I-25 / Palmer Ridge Road
El Paso County

May 29, 2025

RE: Monument Ridge East Filing No. 1 (SF2514)
Monument Ridge Metropolitan District Nos. 1-3 (ID245)

FILE LOCATION: S:\35 1669.002 MONUMENT RIDGE EAST\500 CADD\504 PLAN SET\504 SITE DEVELOPMENT PLAN\SP01.DWG

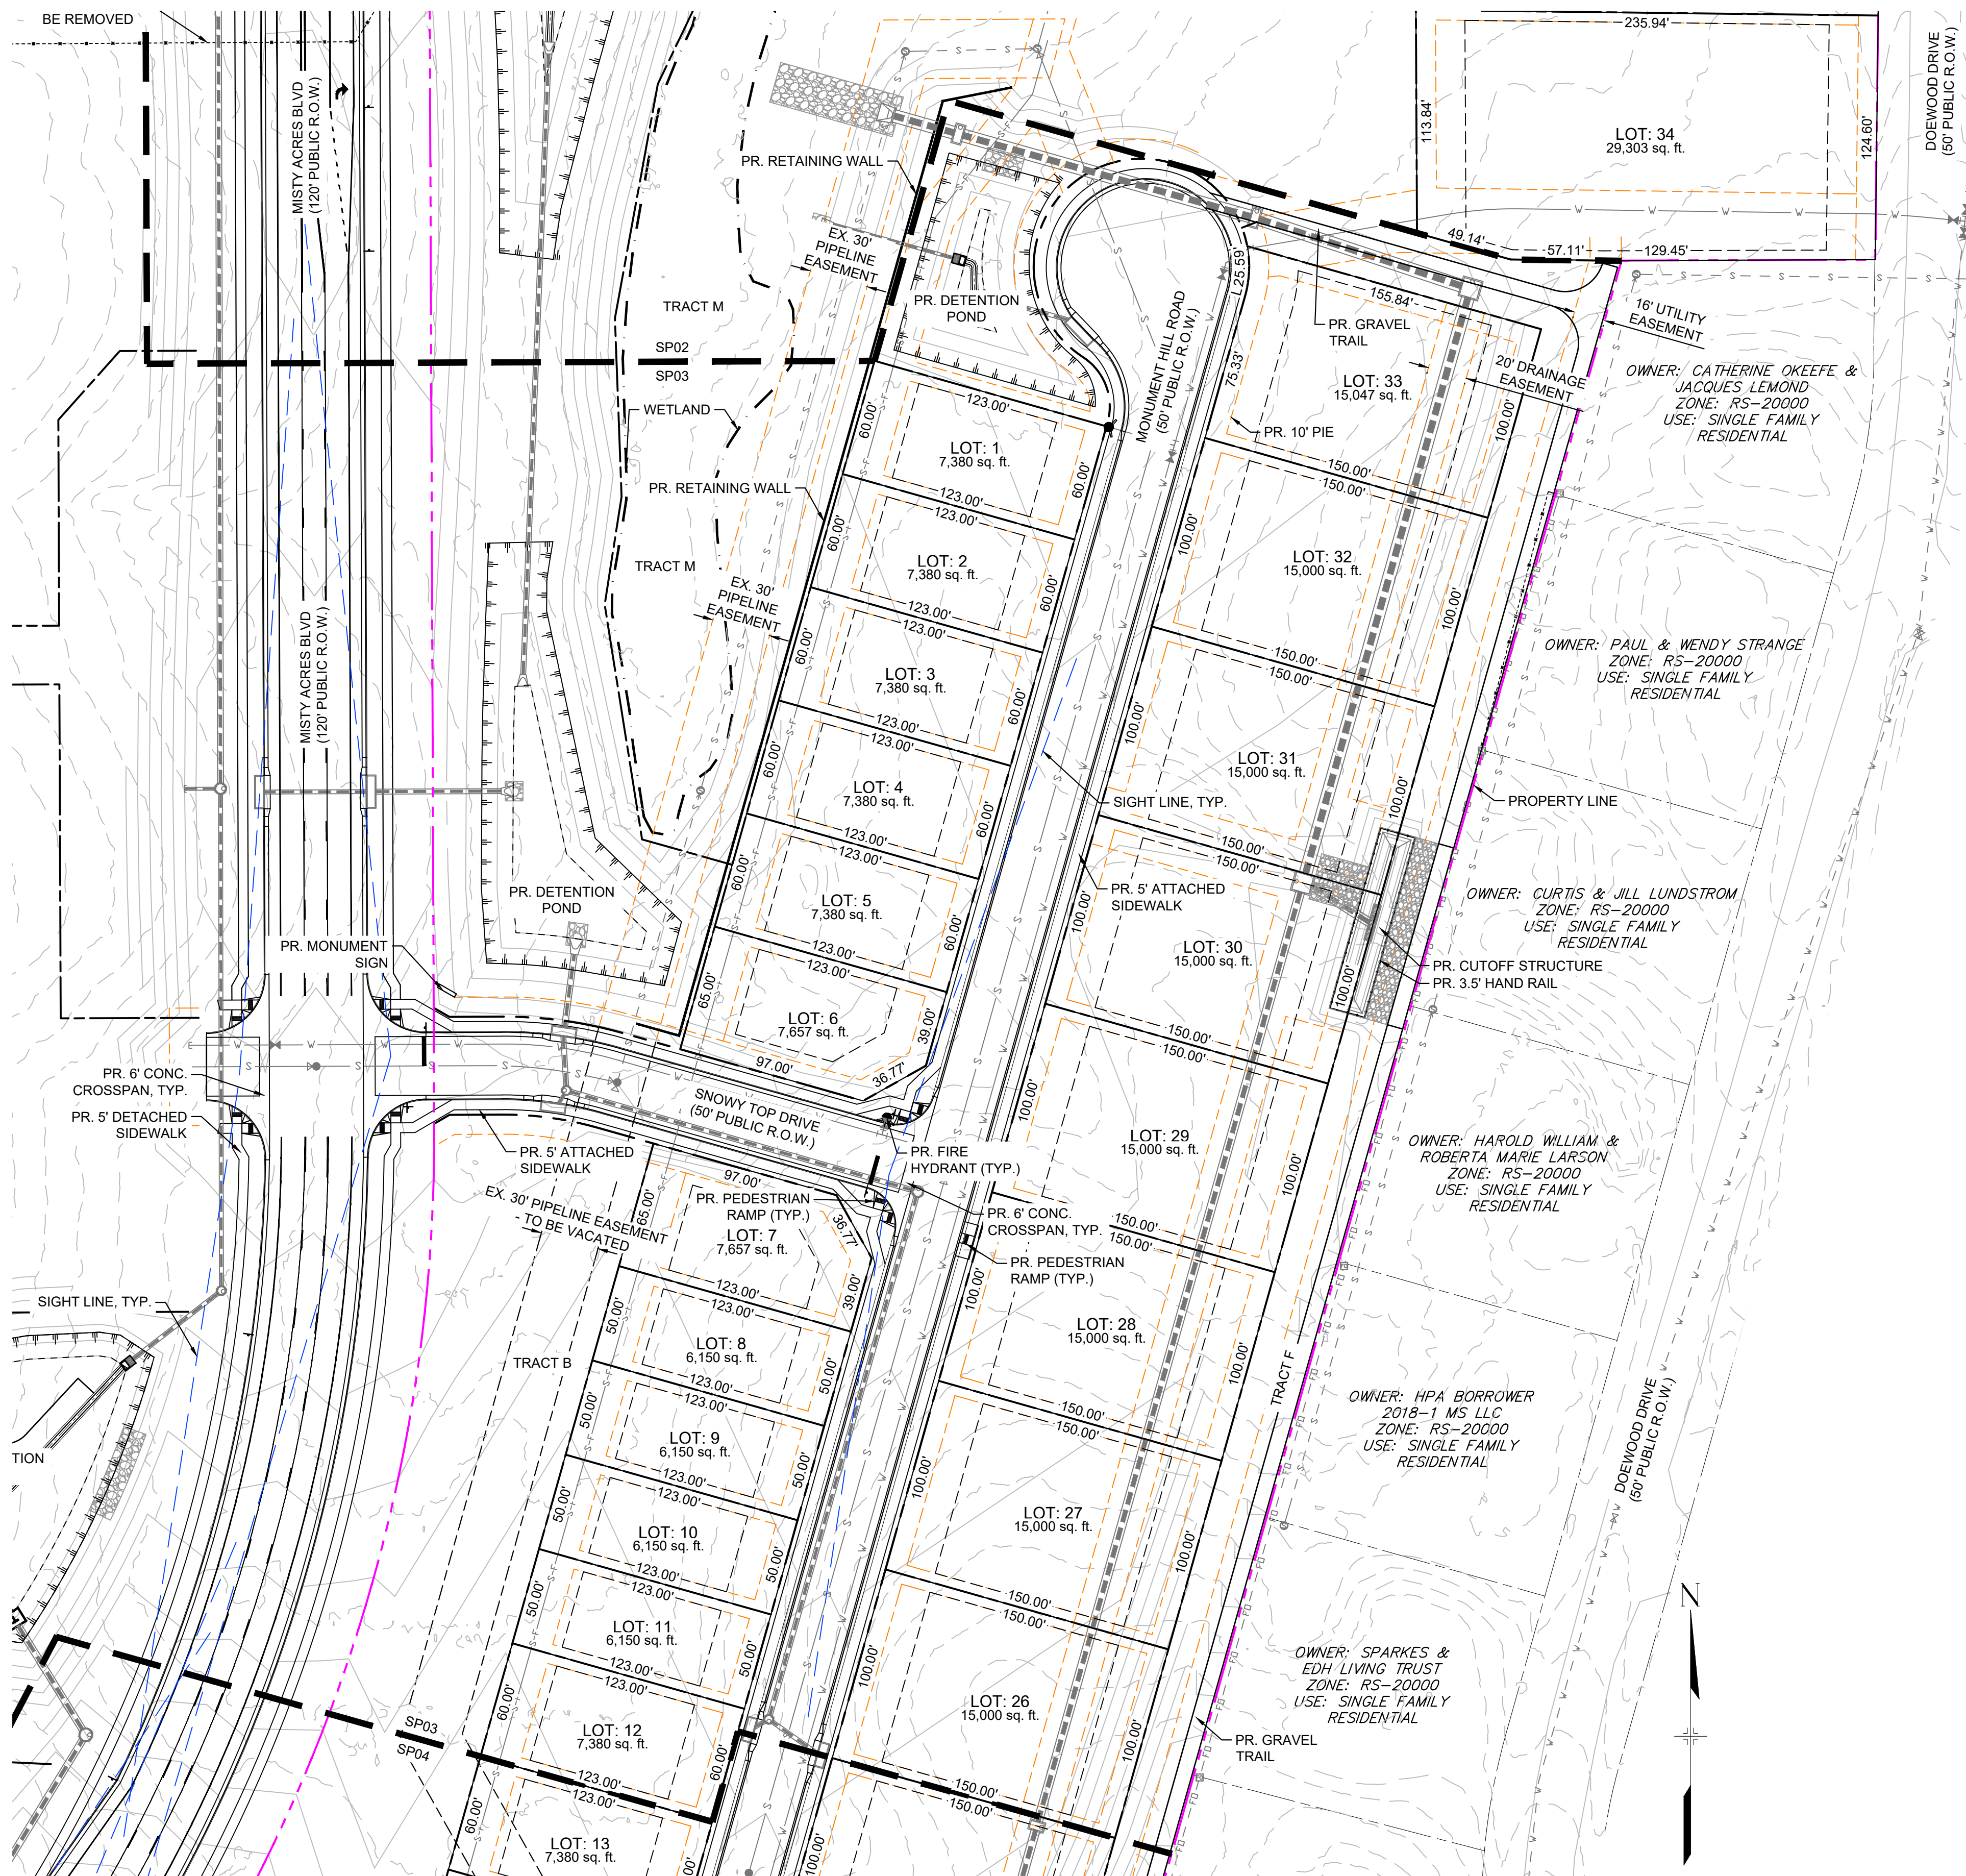
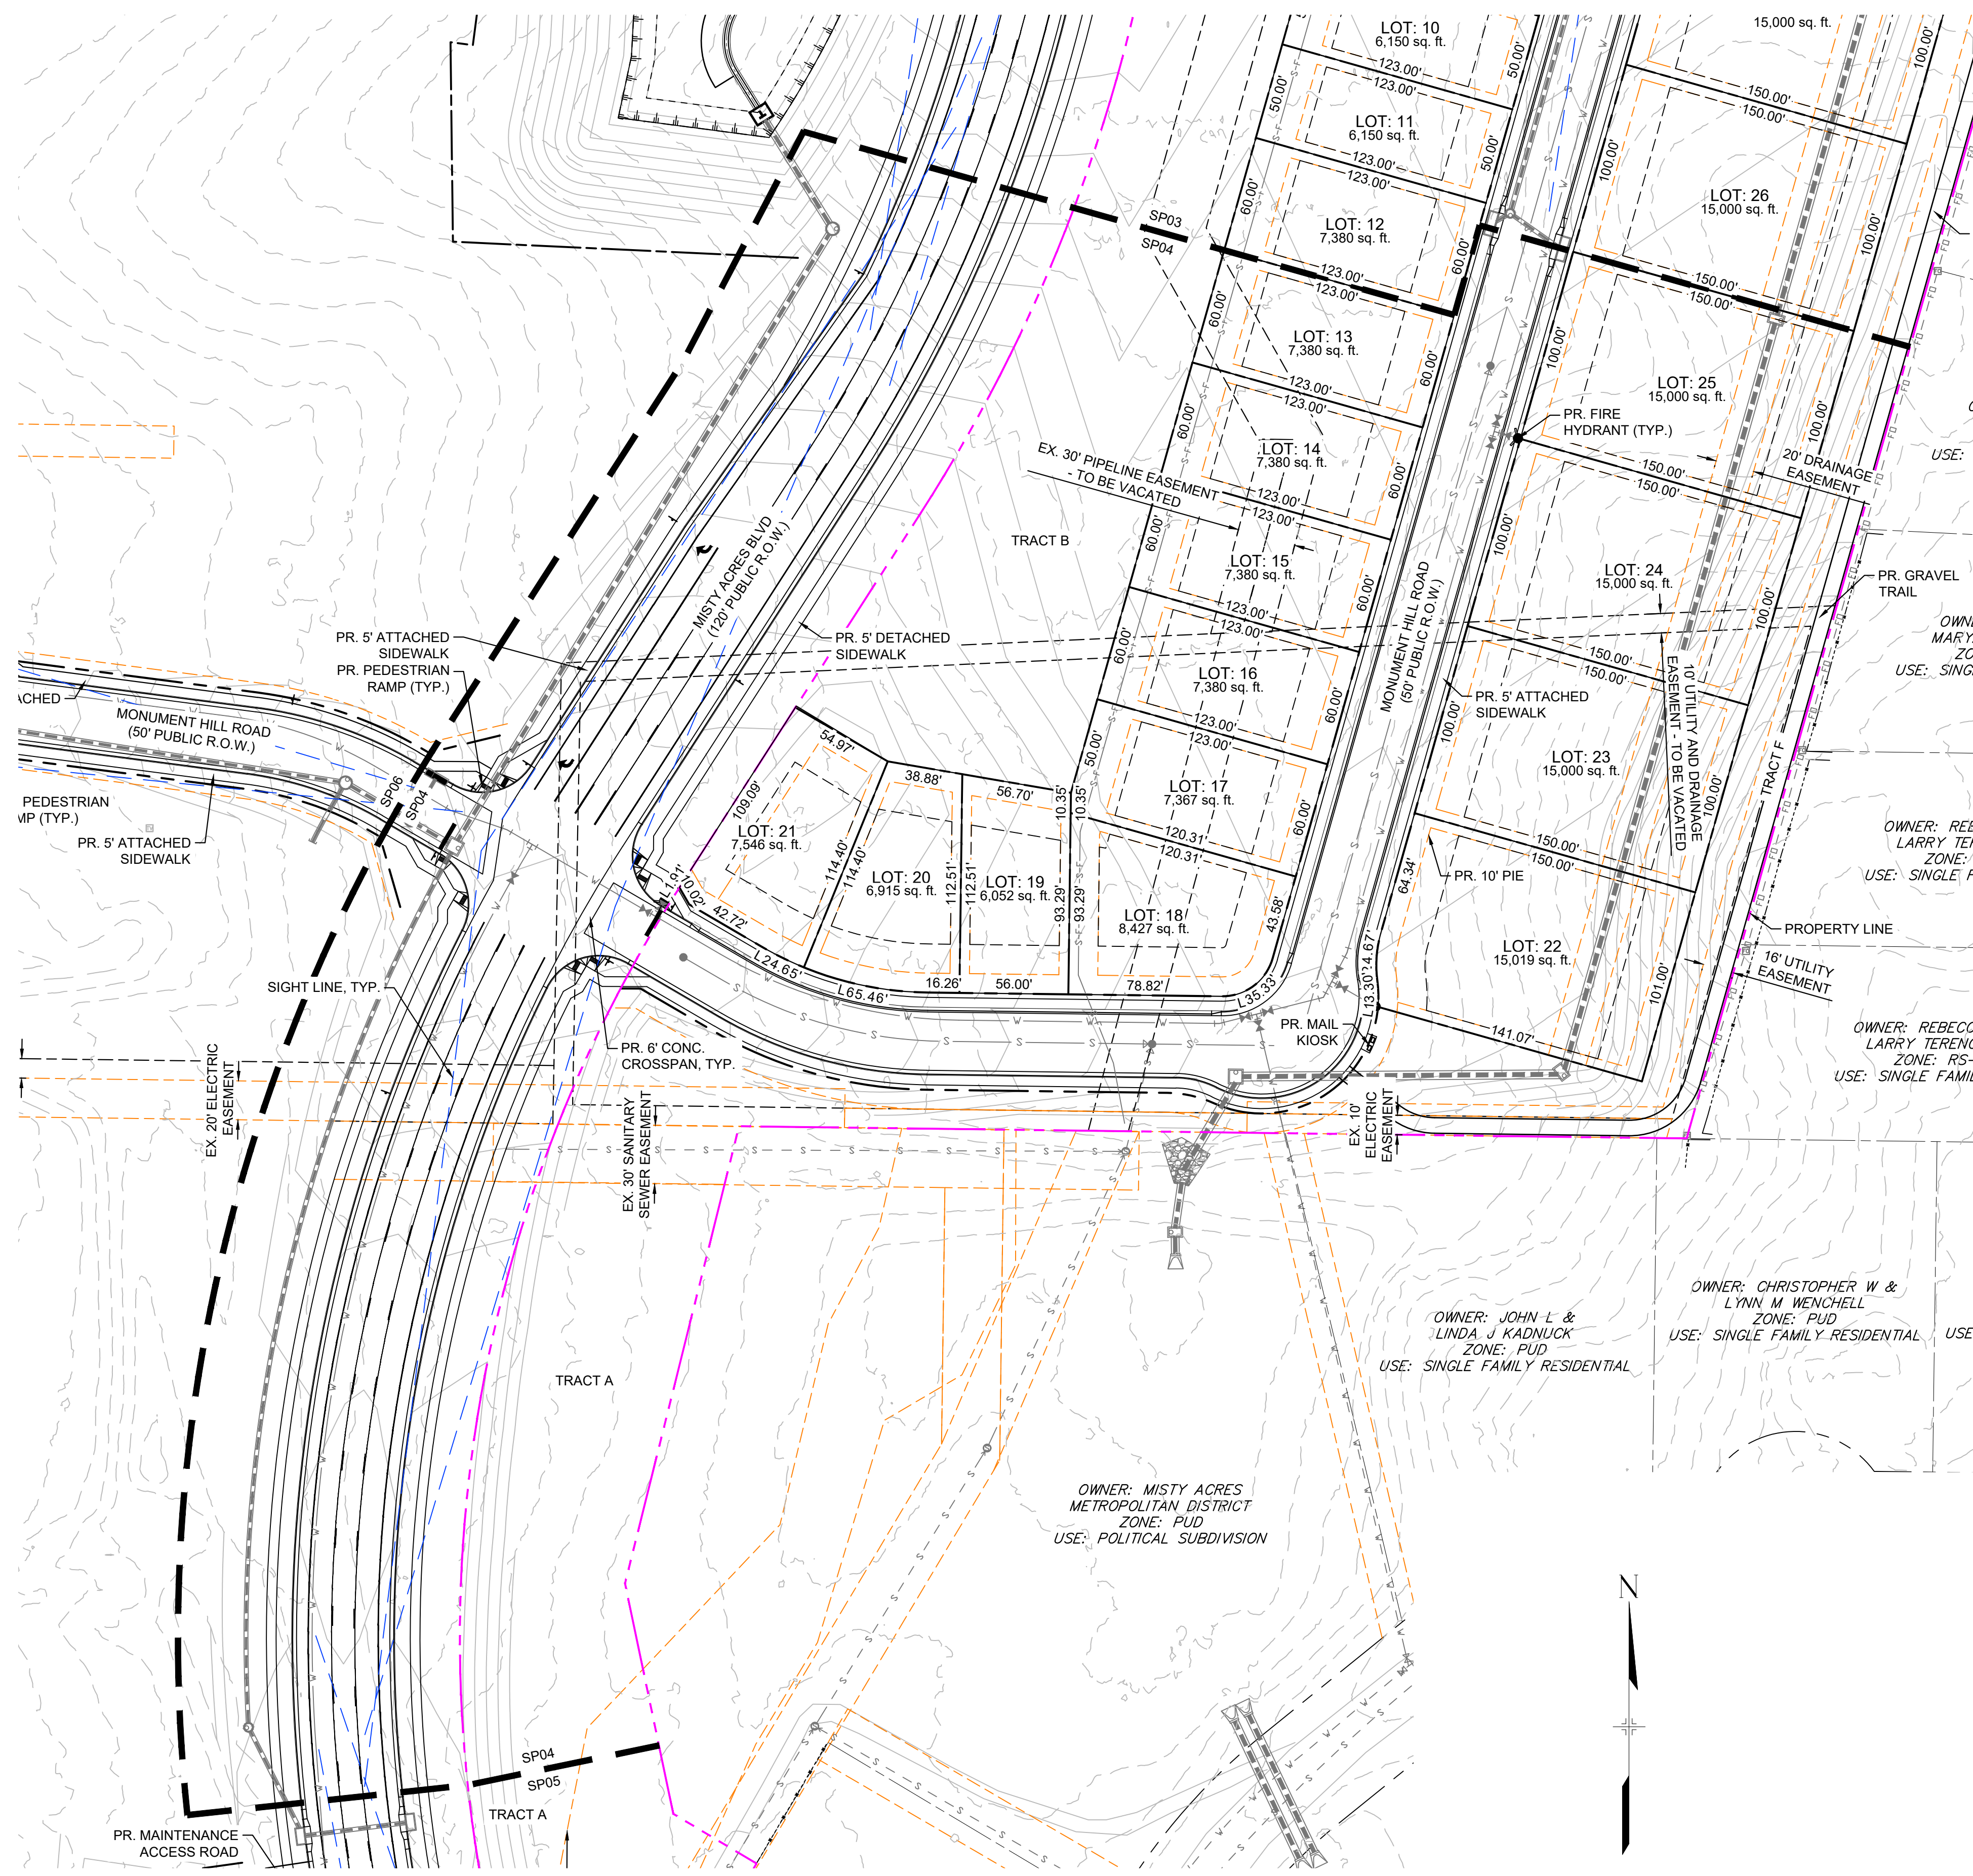
- The Development Plans have a new access from the I-25 Frontage Road. This access is north of the existing deer guard (labeled as a "Cattle Guard" in the plans). If the access (labeled as "Catch slope") is to be constructed, the new driveway will require a new deer guard (similar to the deer guard present) to prevent animals from entering the I-25 corridor. A new deer guard would need to be adequately sized in accordance to the new driveway width. Also, the current placement of the deer guard was solely placed to access this property.

- The Development's connection to East Palmer Divide Ave (not the frontage road) appears to be directly on the existing Deer Guard. This is not shown in the plans. The double CMP are shown, but not the deer guard. The deer guard shall remain in place. A new deer gaurd is suggested since the driveway will create a new access point for deer and elk to enter the highway corridor. This Deer Guard is owned by El Paso County.

- There are no details of how the new proposed access points will connect to the existing wildlife fence.
- Cannot see details or how the new driveway on the north end of the property will accomodate the Monument Hill Road Frontage Road. Looks to be a traffice conflict with driveways being very close.
